Final Acceptance Punch List

Subdivision: Rolling Hills Ranch Filing 1

EDARP File #: SF1923

**Rolling Hills Ranch Filing 1 Phase 1  
El Paso County Partial Acceptance  
Inspection Map**

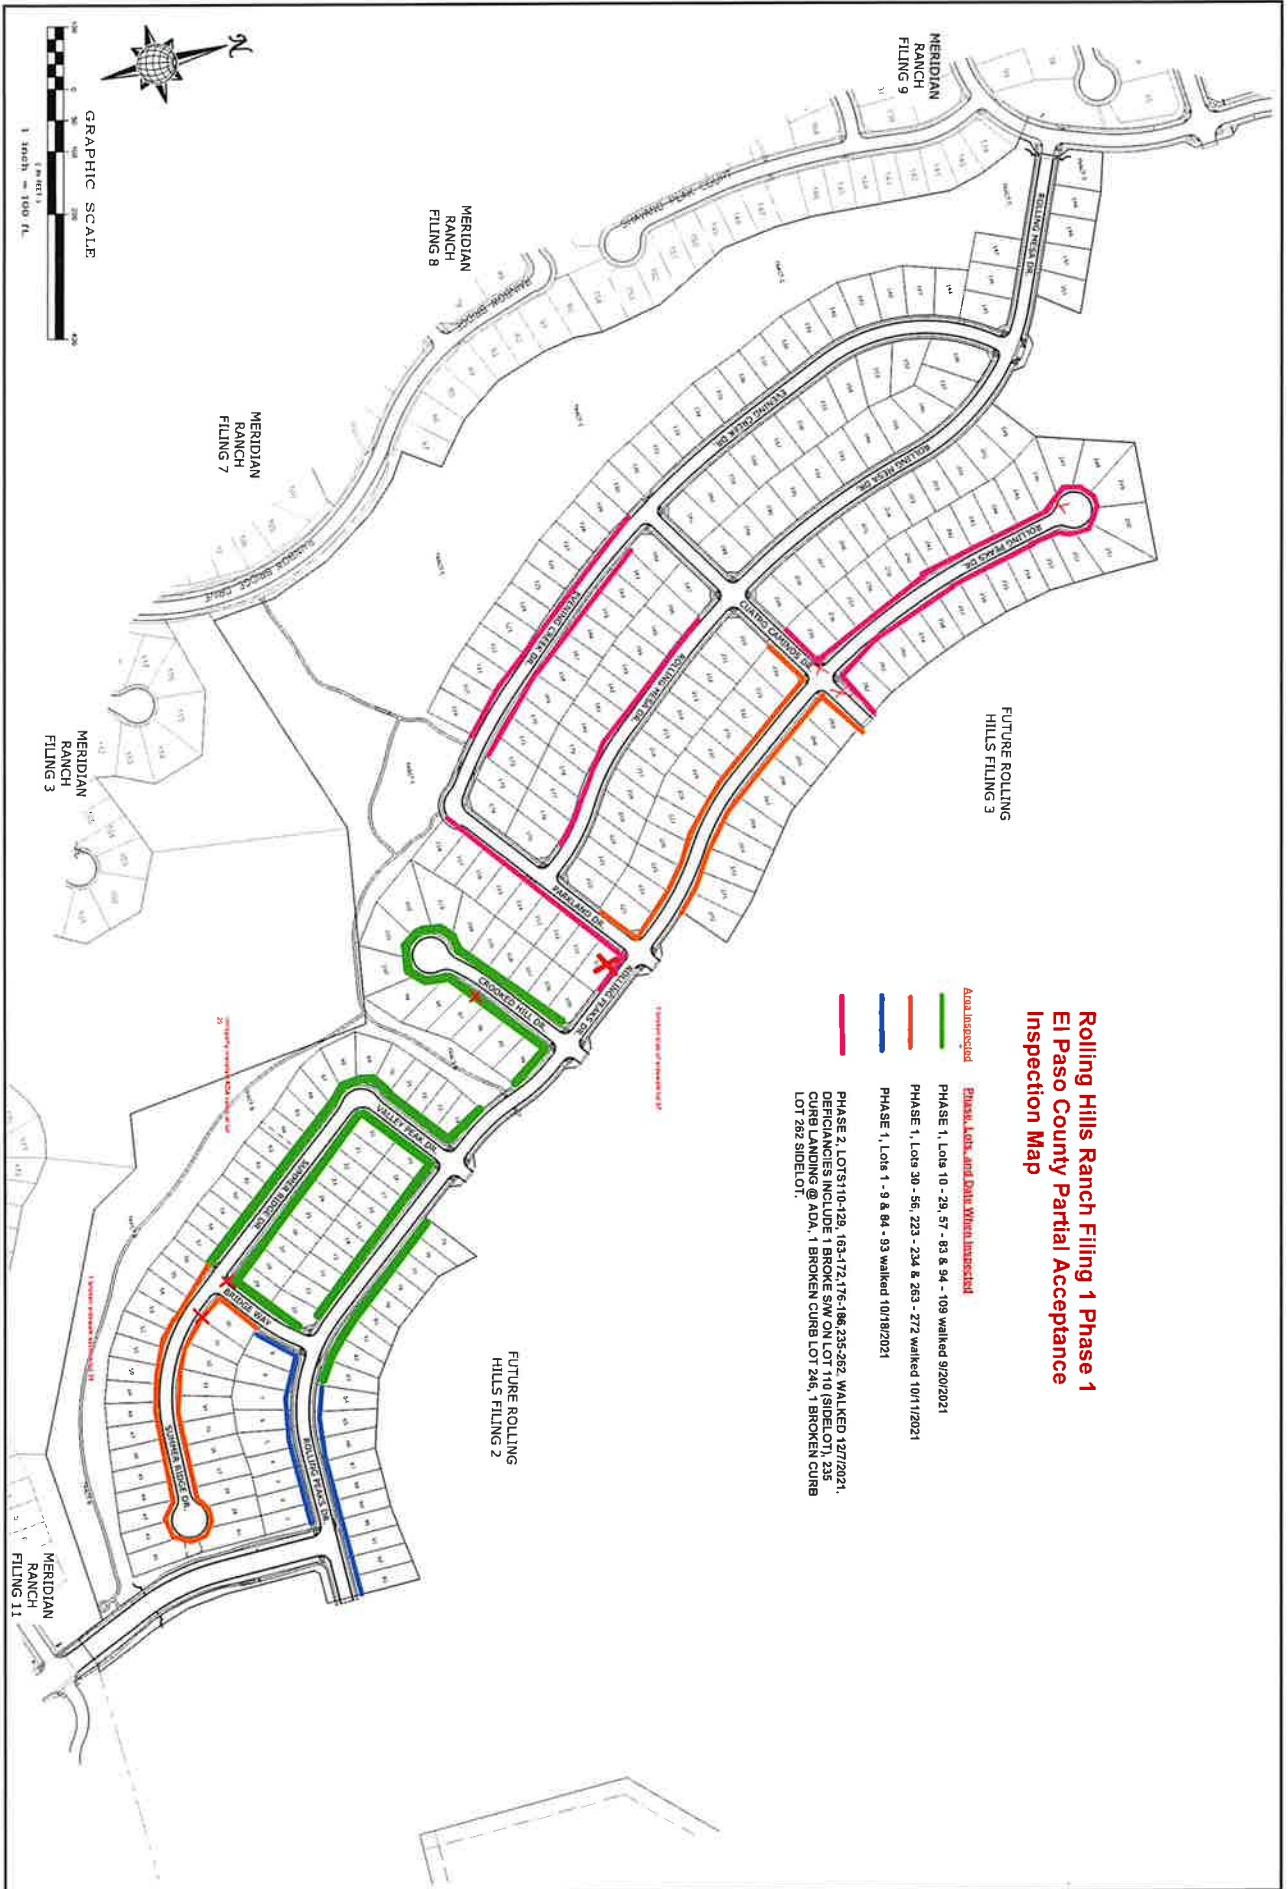
- Remove and replace marked stone on ADA ramp at Rolling Peaks Dr. and Lambert Dr. intersection (east side).
- Remove and replace marked stone on ADA ramp at Bridge Way and Rolling Peaks Dr. (southeast side).

- Asphalt patch for trip hazard at Bridge Way and Rolling Peaks Dr. intersection.
- Remove and replace marked sidewalk stones x2 at the mid block crossing at 10498 Summer Ridge Dr.

- Remove and replace curb and gutter at Valley Peak Dr and Rolling Peaks Dr. intersection (northeast side x1, southeast side x1).
- Patch marked sidewalk stone x2 at the midblock crossing between Valley Peak Dr. and Crooked Hill Dr.

- Grind asphalt patch on Rolling Peaks Dr.
- Remove and replace marked stone on ADA ramp at Rolling Peaks Dr. and Crooked Hill Dr. intersection (southeast side).

- Remove and replace marked curb and gutter x3 at Rolling Peaks Dr. and Crooked Hill Dr. intersection (southeast side).
- Repair wings as necessary on ADA ramp at Rolling Peaks Dr. and Crooked Hill Dr. intersection x2 (northwest side).

- Remove and replace truncated domes x1 on Rolling Peaks Dr. and Crooked Hills Dr. intersection (northwest side).

- Repair ADA stone x1 as necessary to eliminate trip hazard caused by truncated dome at Rolling Peaks Dr. and Crooked Hills Dr. intersection (southwest side).

- Remove and replace marked curb and gutter x1 at the ADA ramp at Rolling Peaks Dr. and Parkland Dr. intersection (southeast side).
- Remove and replace marked curb and gutter x2 at the ADA ramp at Rolling Peaks Dr. and Parkland Dr. intersection (southwest side).

- Remove and replace marked sidewalk stone x1 at the ADA ramp at Cuatro Caminos Dr. and Rolling Peaks Dr. intersection (northwest side).
- Patch marked sidewalk stone x1 at the ADA ramp at Cuatro Caminos Dr. and Rolling Peaks Dr. intersection (southwest side).

- Remove and replace marked curb and gutter at Cuatro Caminos Dr. and Rolling Mesa Dr. intersection (northeast side x1, northwest side x1, southwest side x1).

- Patch ADA wing x1 at Cuatro Caminos Dr. and Rolling Mesa Dr. intersection (southwest side).
- Remove and replace marked curb and gutter x1 at the ADA ramp at Rolling Mesa Dr. and Evening Creek Dr. intersection (southeast side).

- Remove and replace ADA landing at Rolling Mesa Dr. and Evening Creek Dr. intersection (northwest side).
- Remove and replace midblock landing off Evening Creek Dr near Evening Creek Dr and Parkland Dr. intersection (west side).

- Remove and replace marked curb and gutter near the ADA ramp x2 at Parkland Dr. and Rolling Mesa Dr. intersection.
